HINCKLEY NATIONAL RAIL FREIGHT INTERCHANGE

Project reference TR050007

Applicant's response to Deadline 7 Submissions [part 3 - LCC]

Document reference: 18.21

**M69 J2 SOUTHERN BRIDGE STRUCTURE EXTENTS**

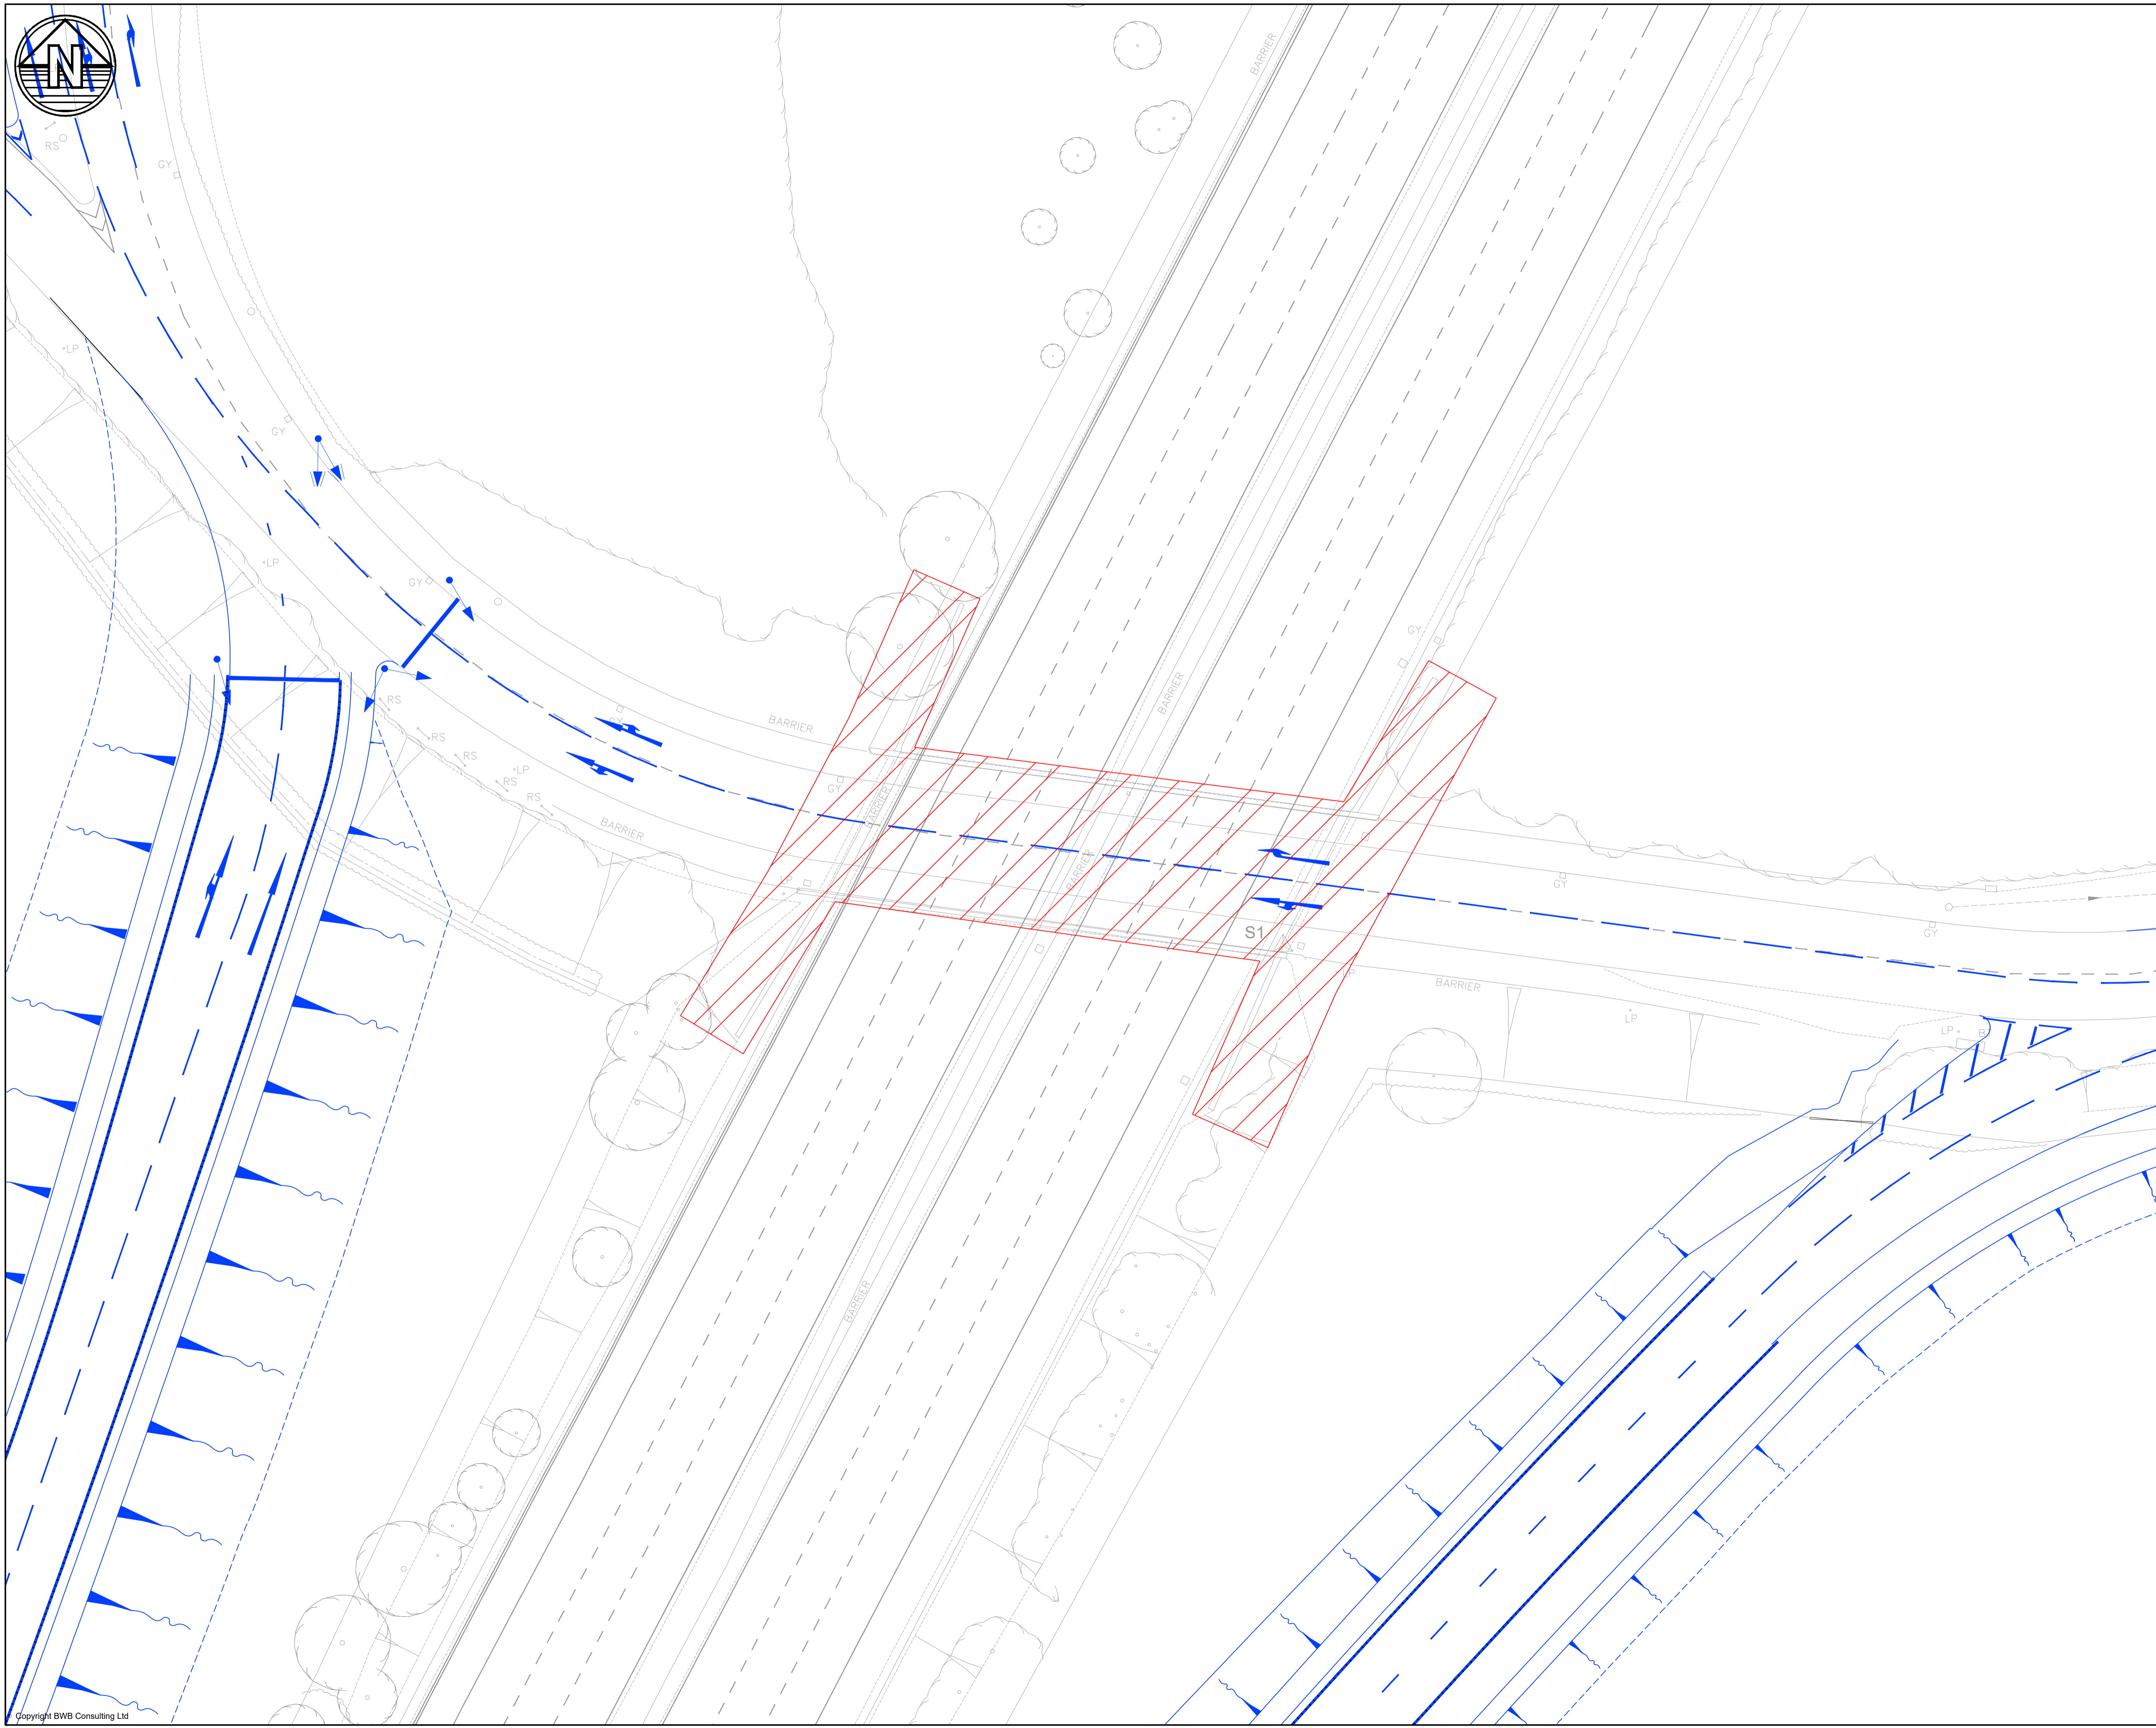
Examination library reference	Document Name	Leicestershire County Council comments	Applicant's Response
REP6-003	2.31.1 M69 Junction 2 Existing Structures Overlaid on Proposed Works	LCC welcome the submission of a drawing to demonstrate that the addition of south facing slip roads can be accommodated without impacting on the existing M69 J2 structures.	Noted. The Applicant assumes that LCC are now content that the south facing slip roads can be accommodated without impacting on the existing M69 J2 structures.
REP6-006 REP6-007	6.2.8.1D Hinckley NRFI ES Appendix 8.1 Transport Assessment - part 15 of 20 - Sustainable Transport Strategy and Plan and Appendices	LCC note that the only updates to this document appear to be references to travel packs, and a DRT app. None of the concerns raised by LCC in its written representations at various Deadlines to date appear to have been addressed.	A revised STS was submitted at Deadline 7 (document reference: 6.2.8.1E, REP7-028) which incorporates further amendments suggested by all Authorities. The Applicant has responded to the submissions made by LCC at all previous deadlines, outlining the approach that has been taken in respect to the points that have been made.
